The Drovers Solar Farm

Appendix 7.1: Consultation and Legislation, Planning Policy and Guidance

Document reference: APP/6.4 (Original)

DRAWING TITLE:
Figure 2-3 Field Numbering

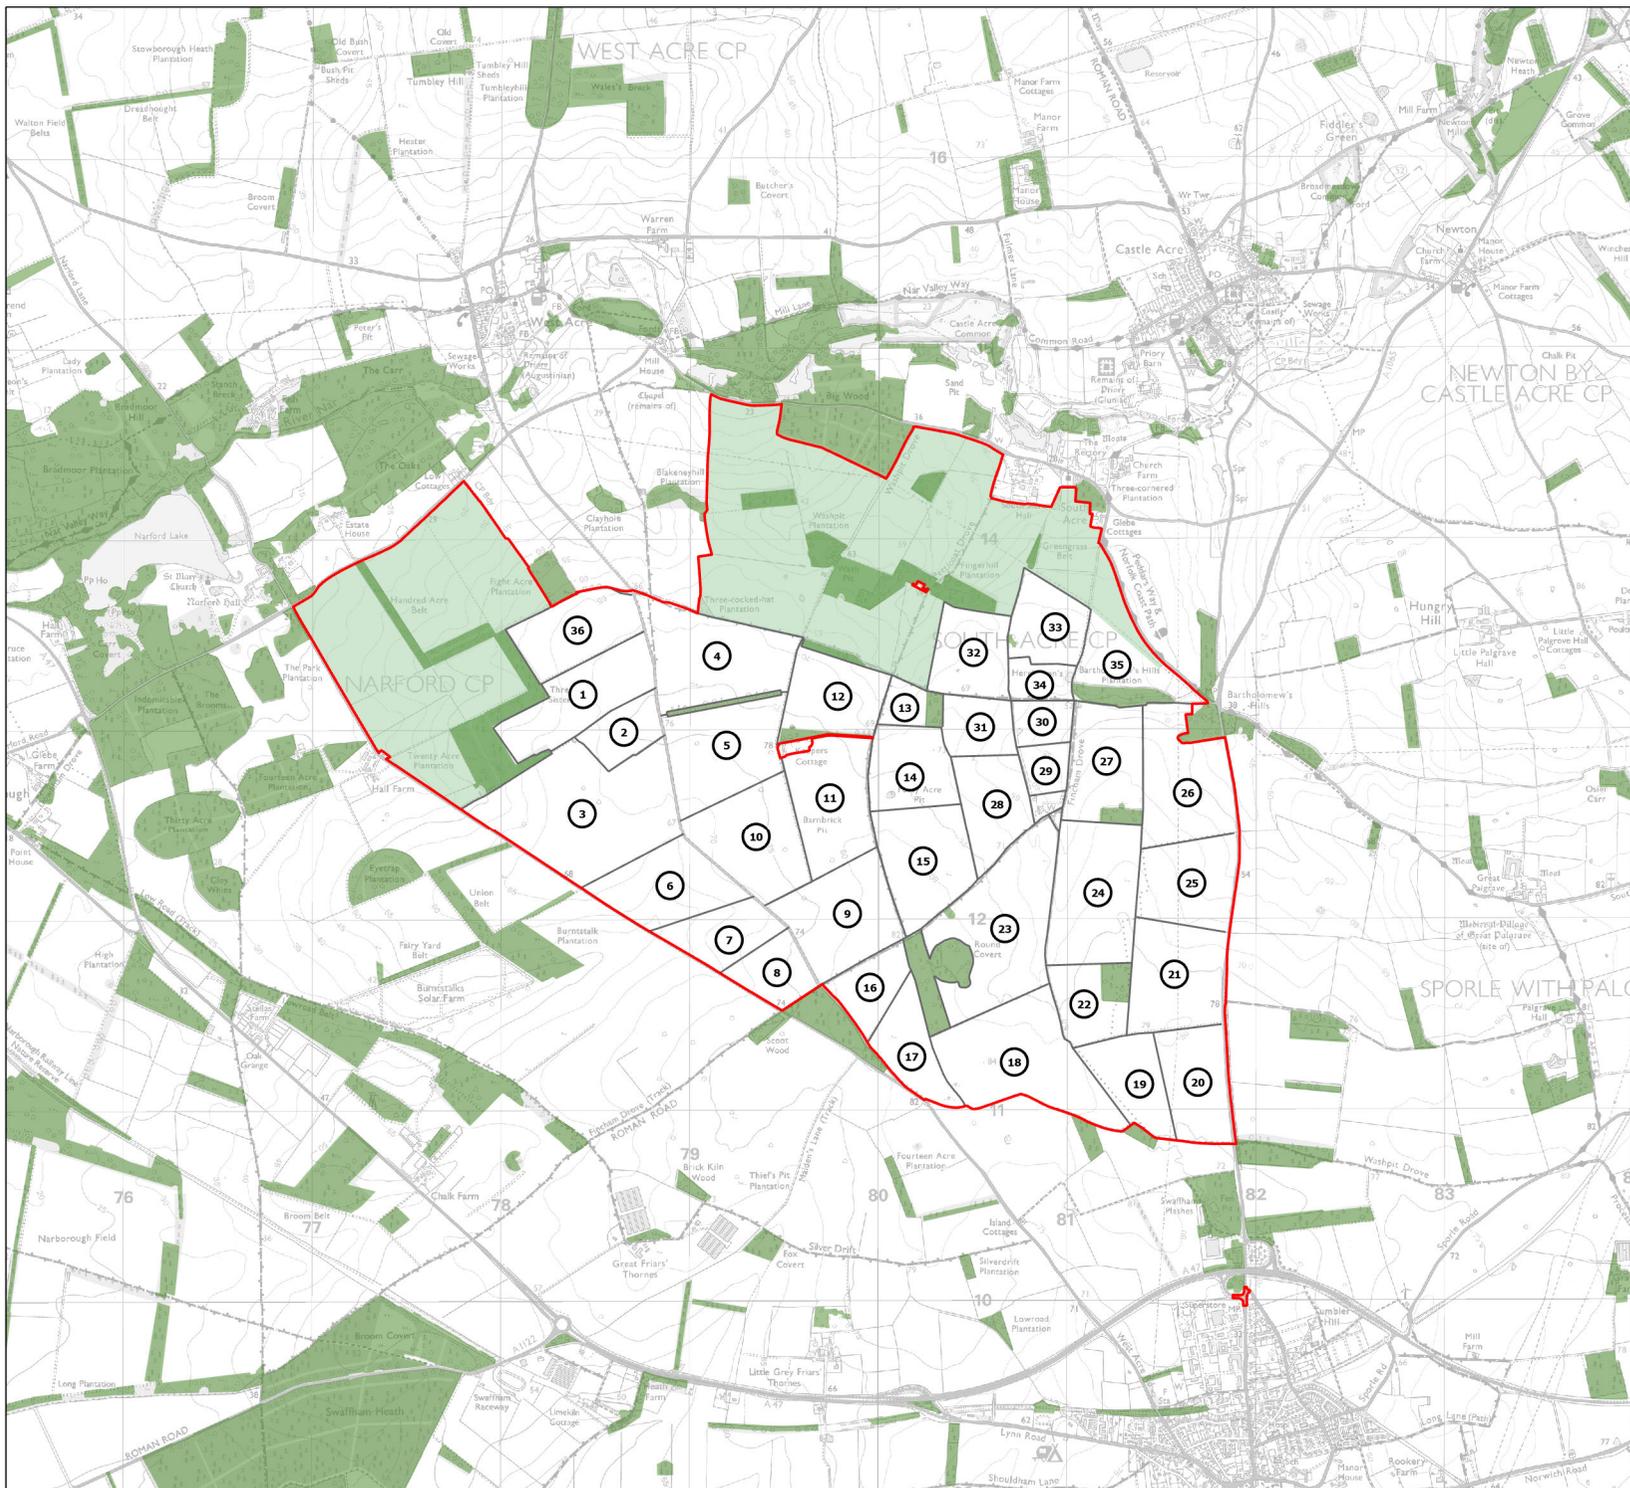
Environment Agency EIA Scoping Opinion, December 2024	<p>Site Boundary:</p> <p>"The EIA scoping report should consider all potential impacts within and adjacent to the Red Line Boundary or 'site boundary'. Currently the ecological surveys are restricted to land within the potential development boundary (Figure 2.3), not the whole site boundary. Land within the site boundary but out-with the</p>	Noted. The Order limits have been refined throughout the design evolution of the Scheme and all land within the Order limits has been surveyed.	ES Appendix 7.2: Baseline Ecological Survey Report [APP/6.4]

potential development area is labelled 'potential mitigation and enhancement area' (Figure 2.2, 2.3). This land also needs to be included in the scope of the Environmental Statement (ES) and appropriate ecological surveys must be carried out."		
Environment Agency EIA Scoping Opinion, December 2024	<p>Non-statutory Designations:</p> <p>"...the following CWS" should be scoped into the assessment:</p> <ul style="list-style-type: none"> • Land Adjacent to the River Nar (895, 945, 902) • Narford Lake • Priory Meadow • Land West of Castle Acre • Mill House Lake 	These non-statutory designations are assessed within ES Chapter 7: Ecology and Biodiversity [APP/6.2] .	Section 7.8 of ES Chapter 7: Ecology and Biodiversity [APP/6.2] .
Environment Agency EIA Scoping Opinion, December 2024	<p>Protected Species and Biodiversity:</p> <p>"Impact assessment on mammals using the site should include assessment of the fencing which will be used to enclose the site, and the impact this has on excluding mammals from their range."</p>	Specific consideration in regard to the potential impacts of proposed fencing on mammals is included within ES Chapter 7: Ecology and Biodiversity [APP/6.2] .	Section 7.8 ES Chapter 7: Ecology and Biodiversity [APP/6.2] .
